CITY OF ALBUQUERQUE

October 2, 2025

**RE: Capra Bank Albuquerque
5171 Lang Ave. NE
Grading and Drainage Plan
Engineer's Stamp Date: 07/26/2025
Hydrology File: D17D106D
Case # HYDR-2025-00337**

GRADING, PAVING AND DRAINAGE PLAN - PHASE 1 BUILDING
C-400

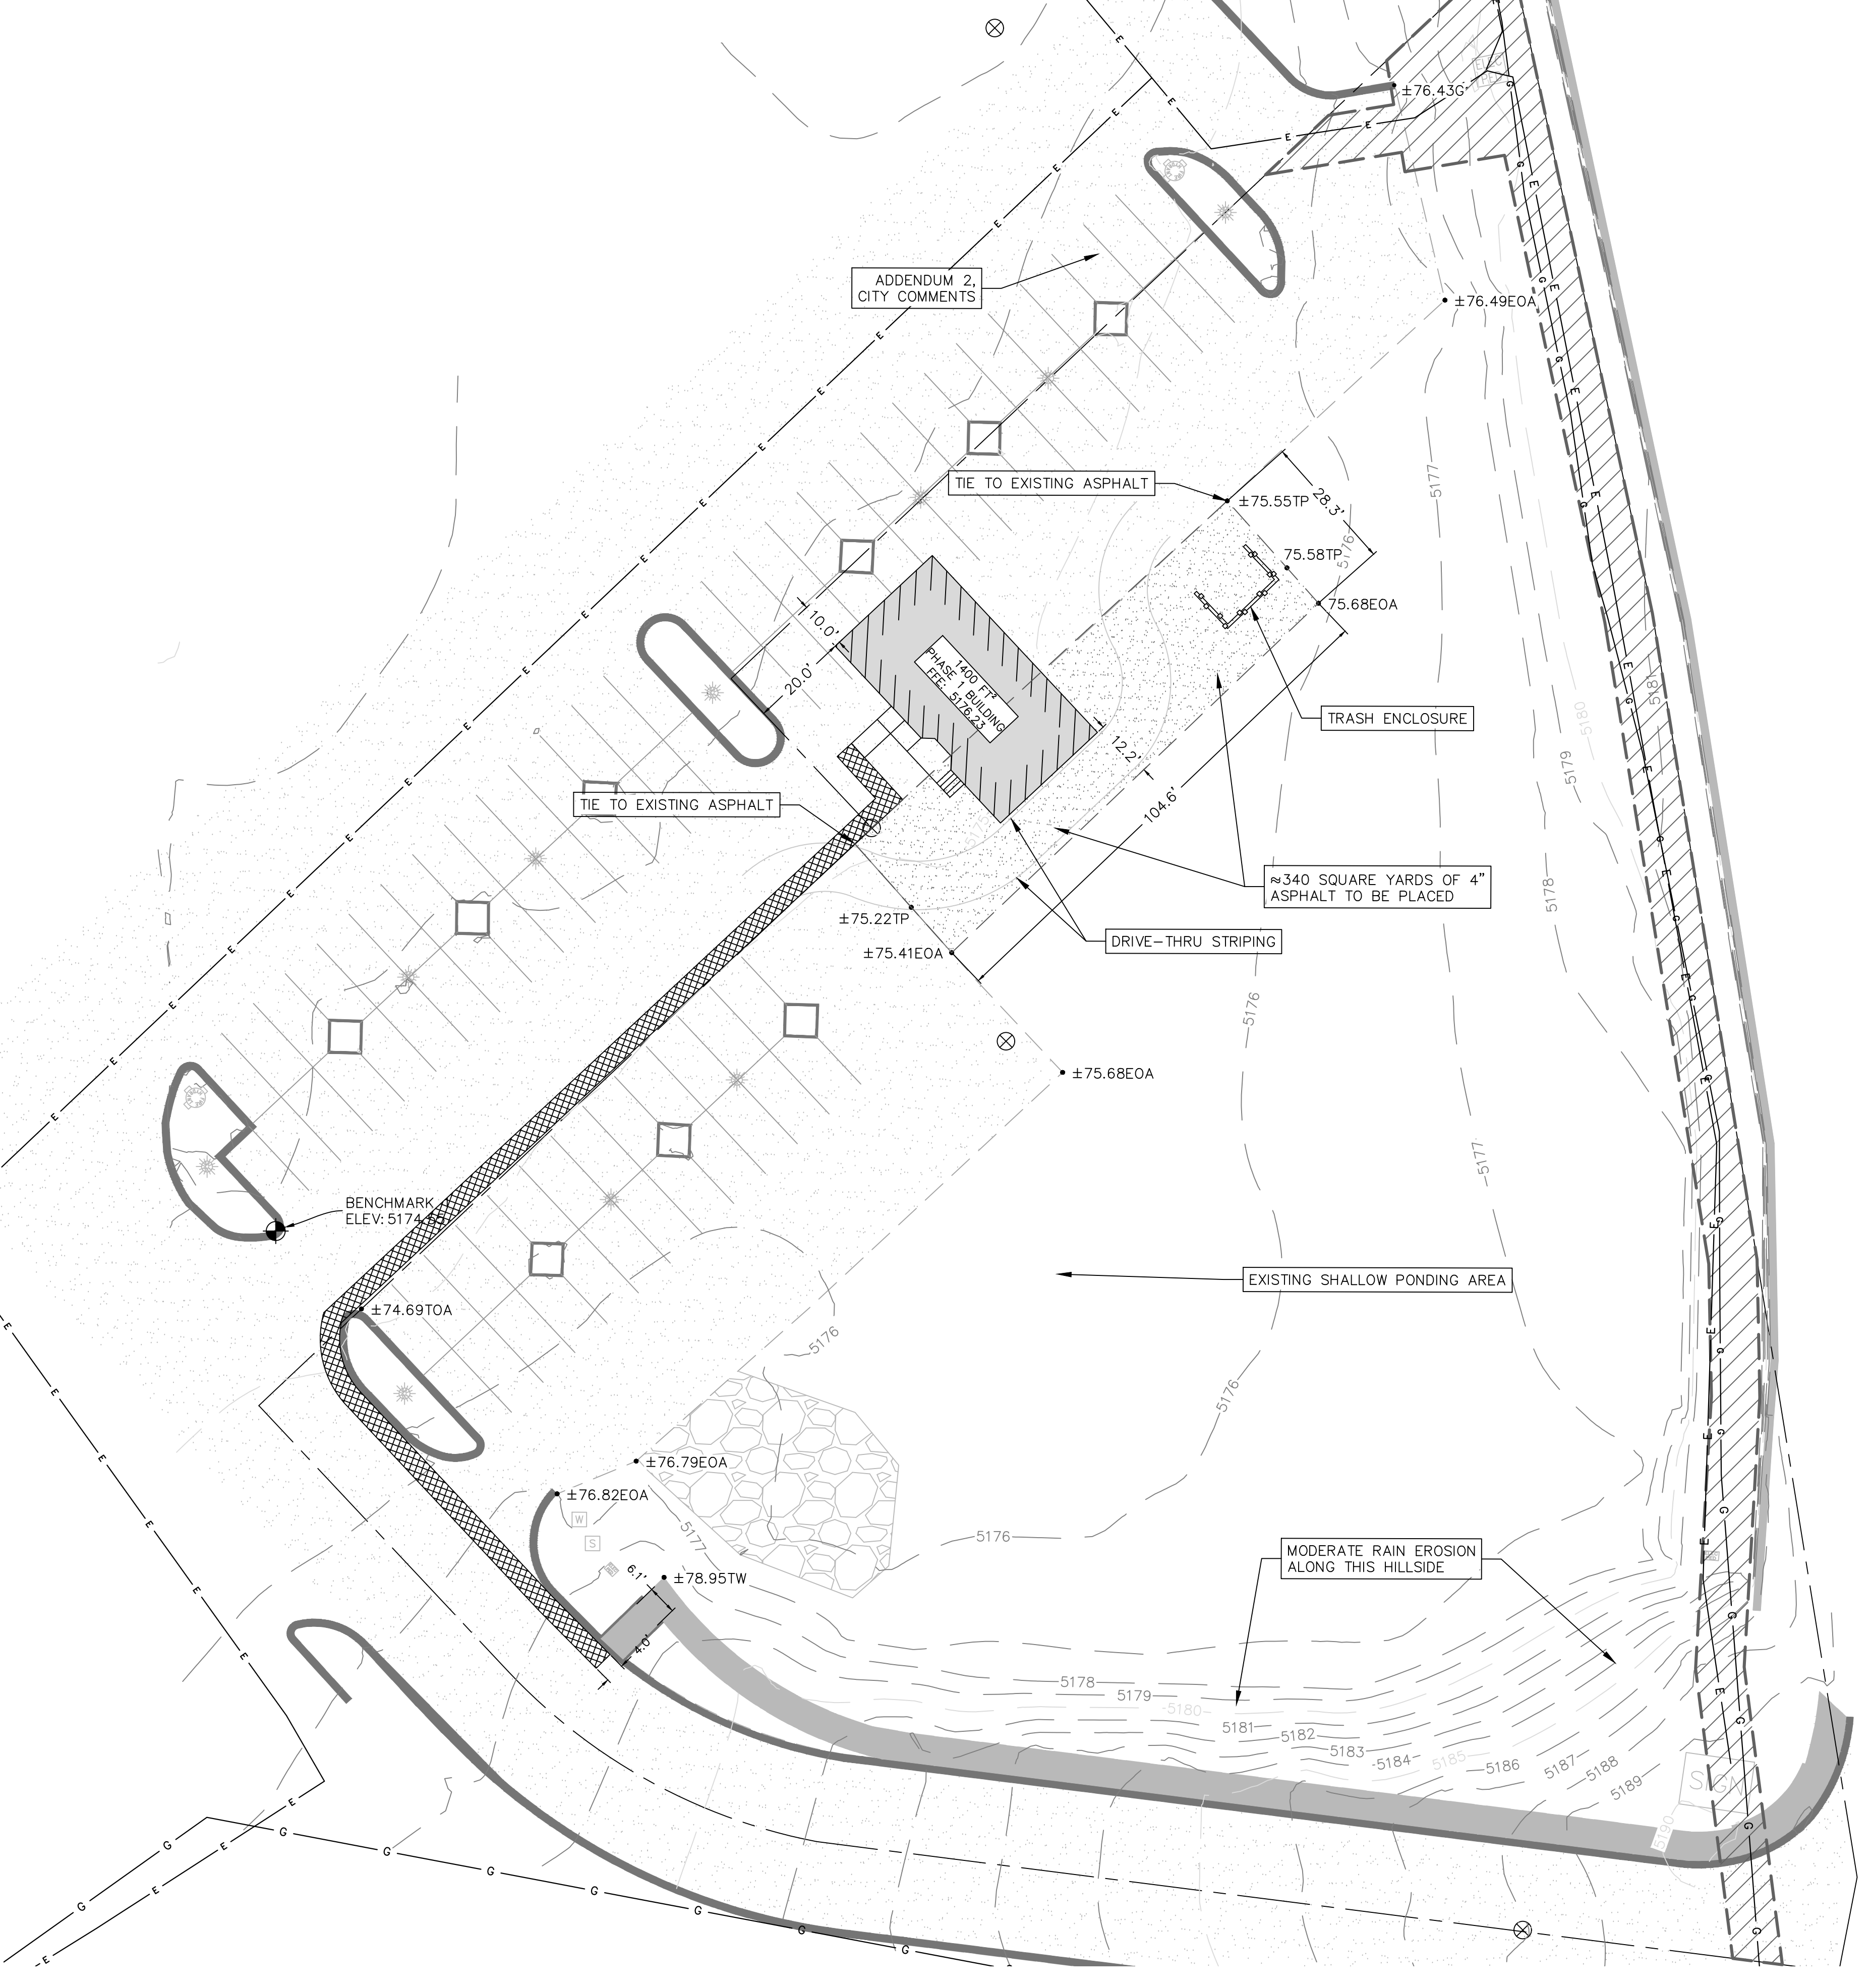
1. Per the [DPM](#), the following must be on the Grading Plan. Please note the Grading Plan must be a stand-alone construction document:
 - Please use 1" = 20' for the scale. (This may make two sheets)
 - Please provide a Vicinity Map. This can be downloaded in pdf format from the City of Albuquerque's website.
 - Please provide the Benchmark information (location, description and elevation) for the survey contour information provided.
 - Please provide the FIRM Map and flood plain note with effective date.
 - Please provide a legal Description of the property.
2. If only seeking Site Plan for Building Permit approval at this time, label the grading plan "Conceptual, Not For Construction" or similar and address the SPBP comments. If seeking SPBP and Building Permit simultaneously, forgo the conceptual markings and address all SPBP and Building Permit comments.
